**Re: SSD 6954 IKEA Multi-Function Logistics Unit, Sydney Business Park,
Marsden Park**

The proposal has been reviewed by Council officers and is not supported in its current form. A range of issues have been raised and listed in **Attachment A** to this letter, which are requested to be addressed to Council's satisfaction by the Proponent before any determination of the proposal is made by the Department. Council requests the opportunity to provide conditions of consent prior to the determination of the application.

ATTACHMENT A

Approved Application No. **SSD 6954**

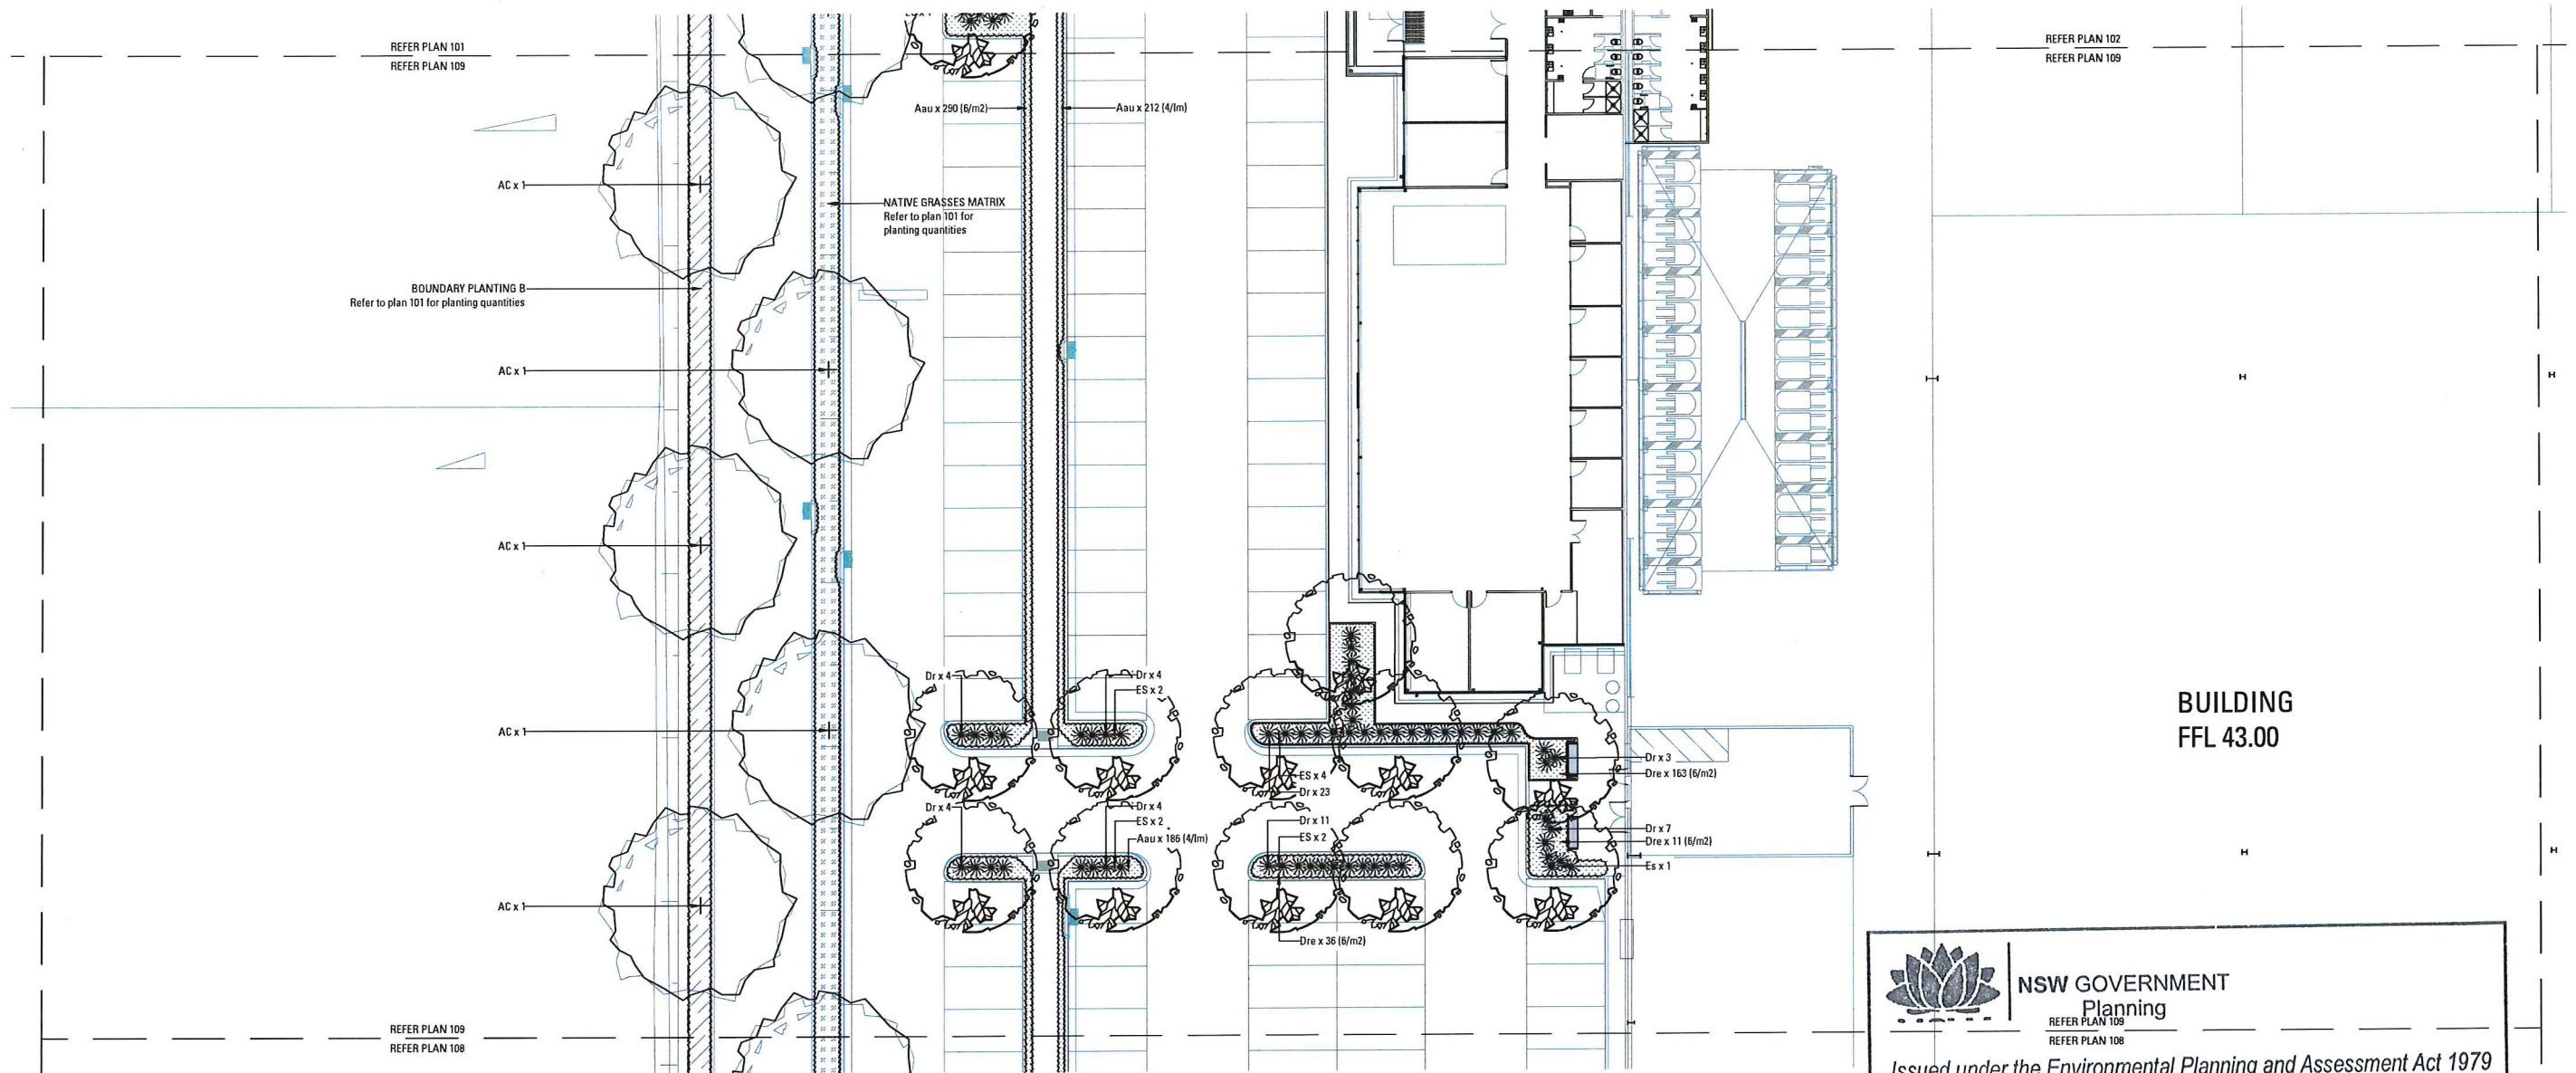
5. The proposed landscape plans demonstrate a suitable design of trees and plantings, however concern is raised that the proposed pot sizes are not satisfactory. Therefore, suitably sized trees, shrubs and plantings are required to be demonstrated on the plans which demonstrate that the resulting planting will suitably complement the proposed building and reach maturity in a suitable timeframe.

RETAINING WALL 1 (190 BLOCKWORK)
SCALE 1:50

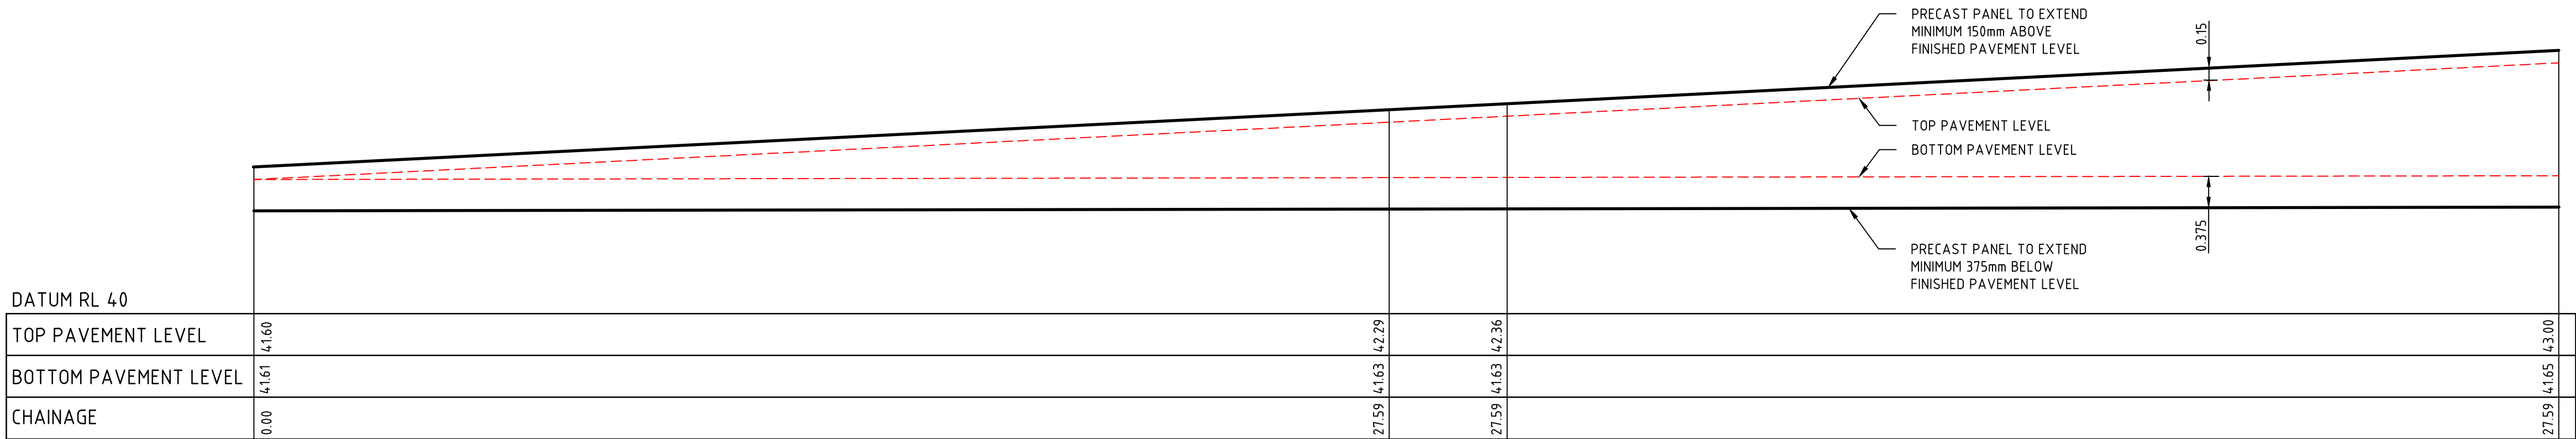
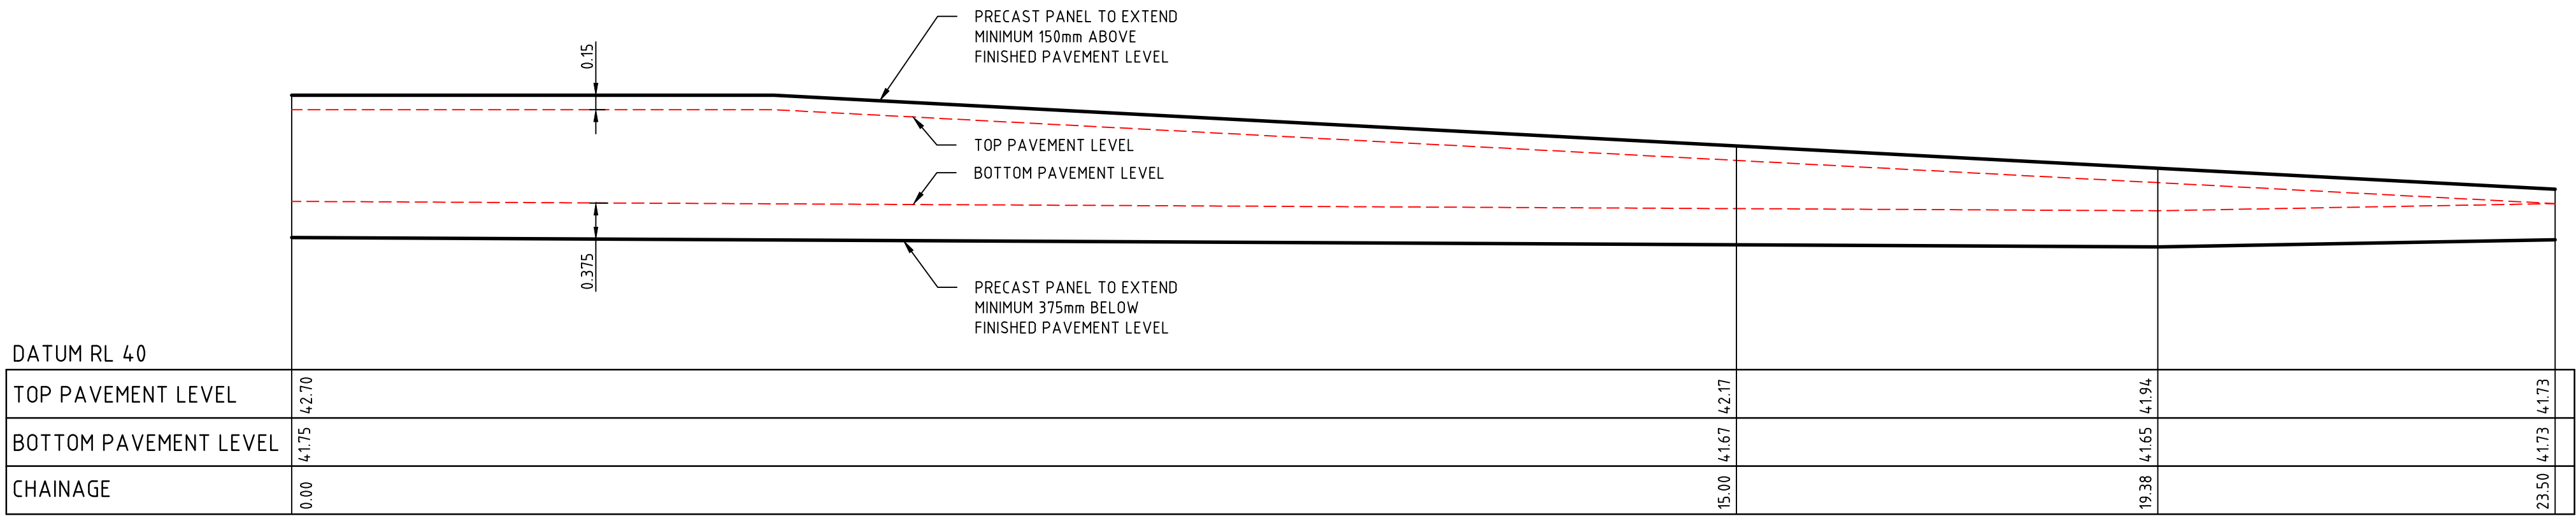
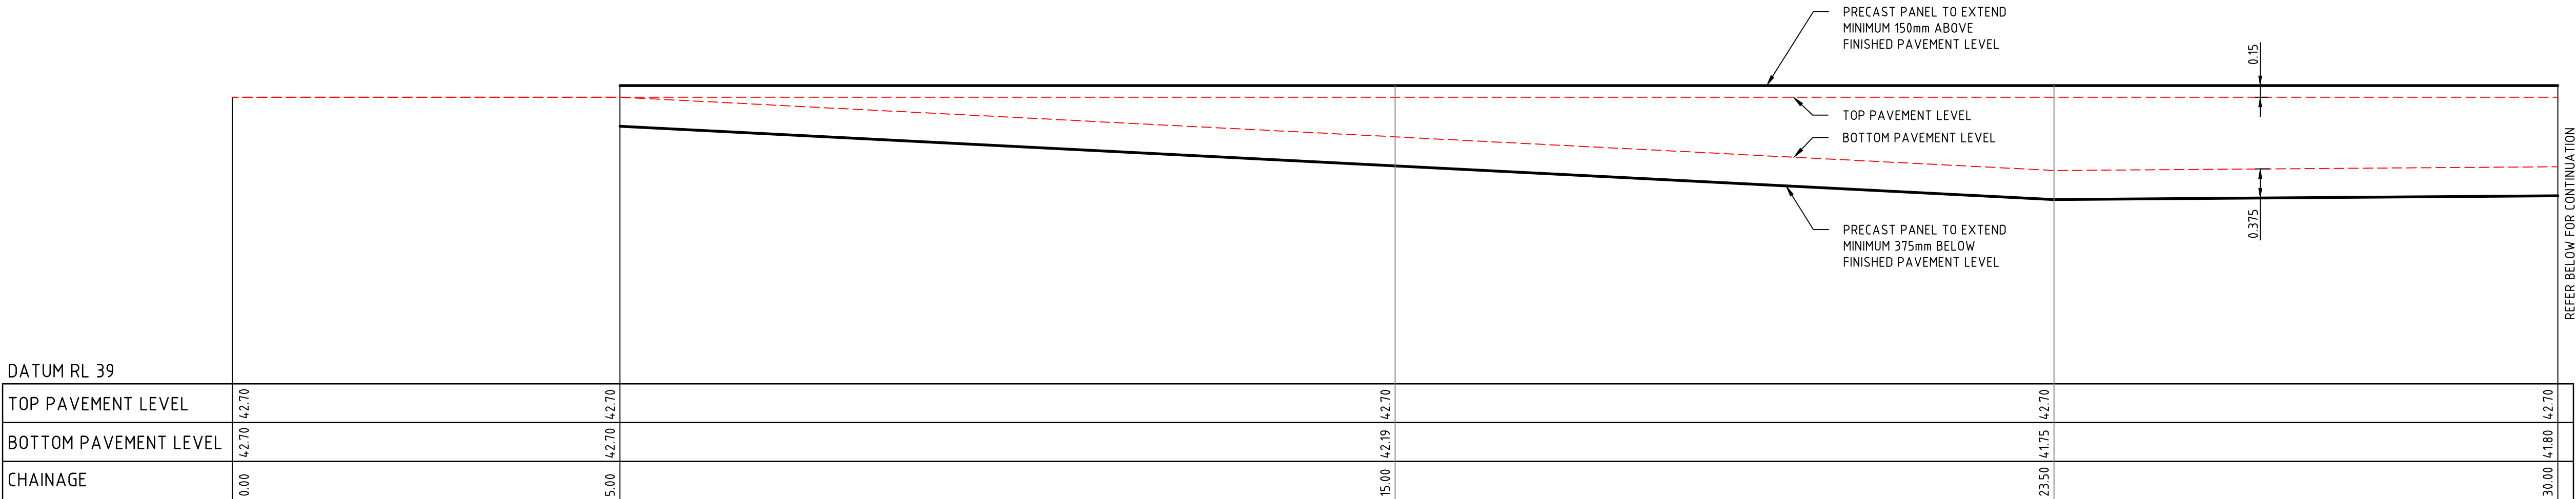
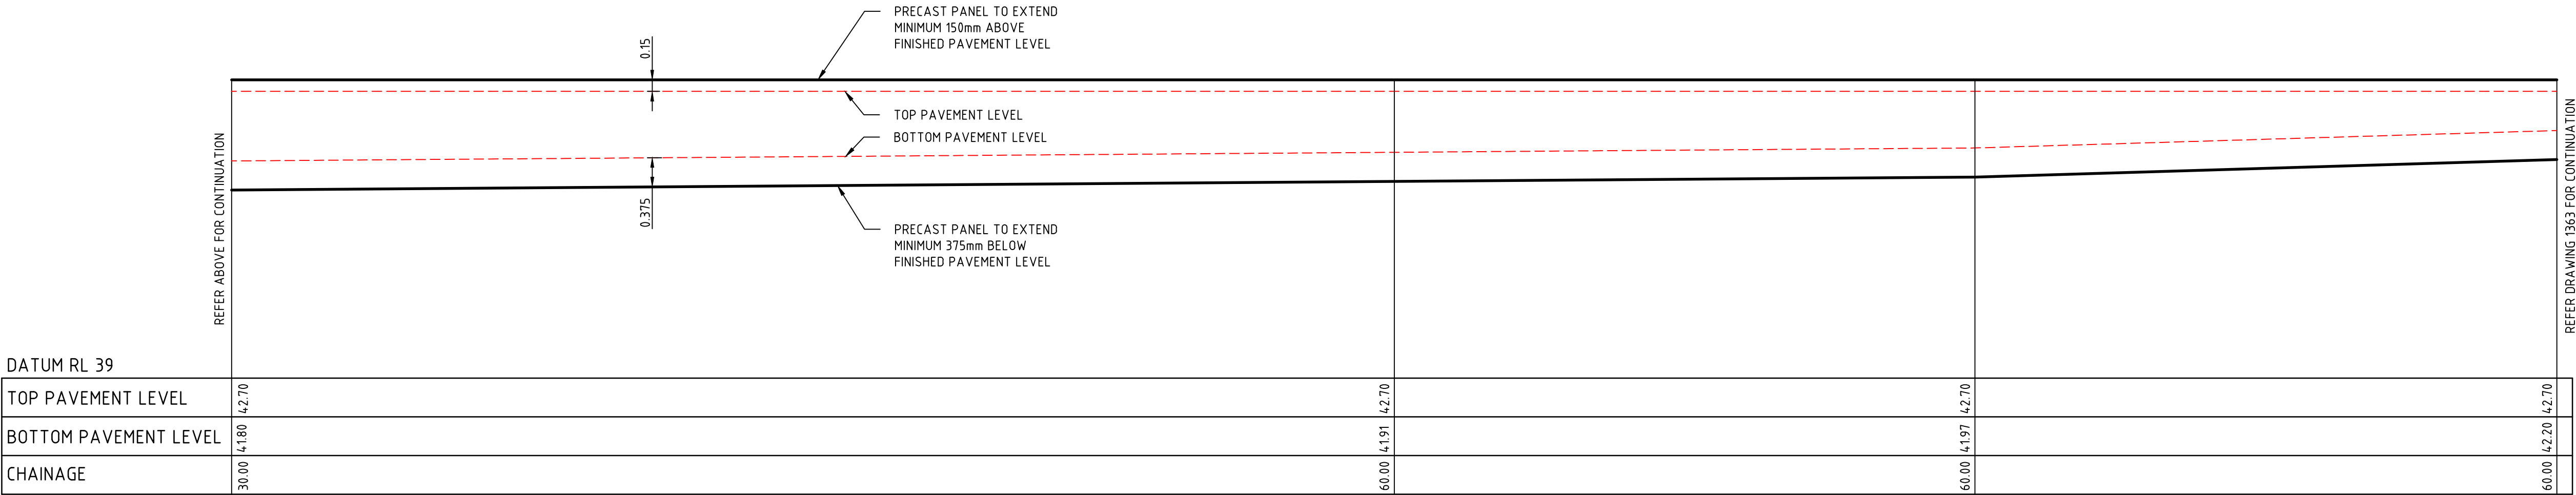
7. The proposed boundary fencing and retaining walls are to be clearly demonstrated on the plans.

**SOUTH ELEVATION (Elev 1)**  
SCALE: 1:500

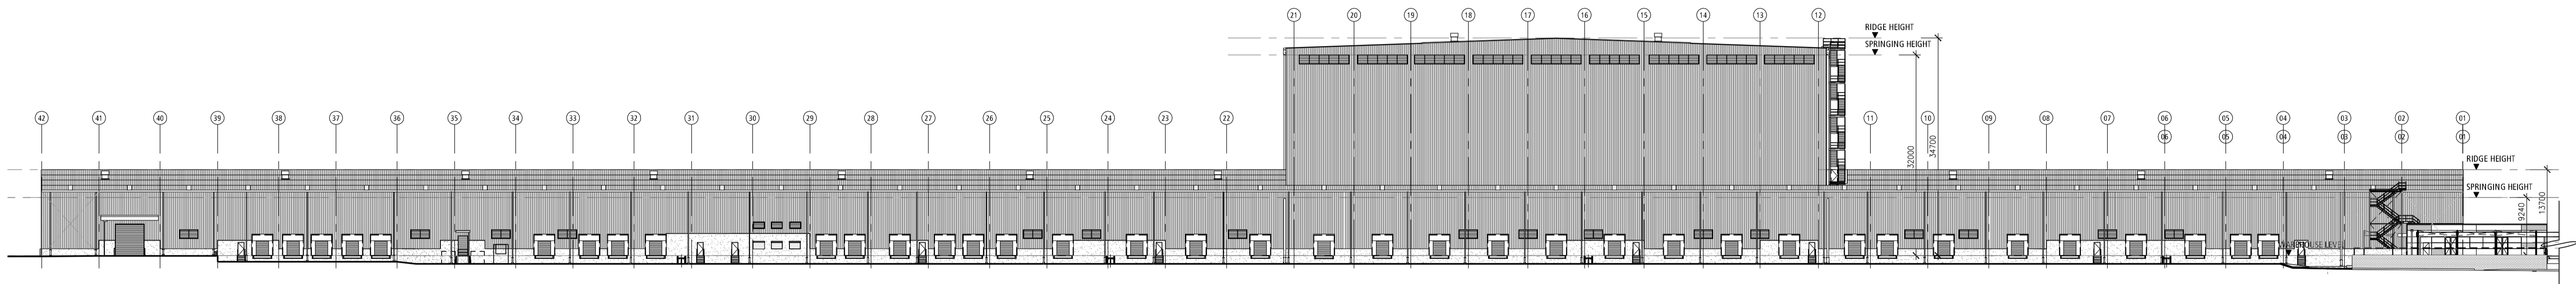
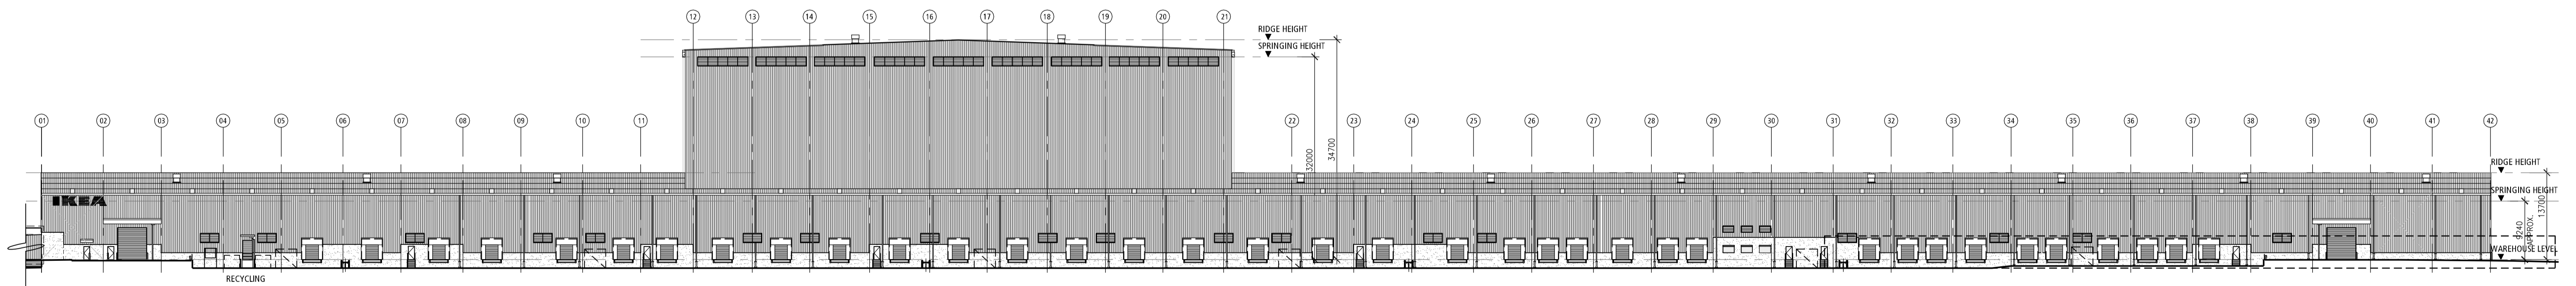
6. As raised in Council's correspondence dated 3 June 2015, the overall building design was considered to result in a poor presentation, and this concern remains as the proposal in its current is not considered to demonstrate high quality building design. This is particularly the case given the proposal is almost double the permitted building height and provides a poor built form which is considered to contravene the objective of clause 4.3 Height of Buildings as follows:

It is recognised that the central building form is the result of the internal functionality of the high bay storage system sought by the Proponent. However, this internal system does not constrain the exterior presentation of the building, which is capable of providing a high quality built form, as is the expectation of other recently approved warehouse buildings within the Marsden Park Industrial Precinct. To maintain the quality of the new built forms in this precinct, the design of the building is required to be improved so as to demonstrate design excellence and comprise suitable architectural design measures. The proposal in its current form is not supported.
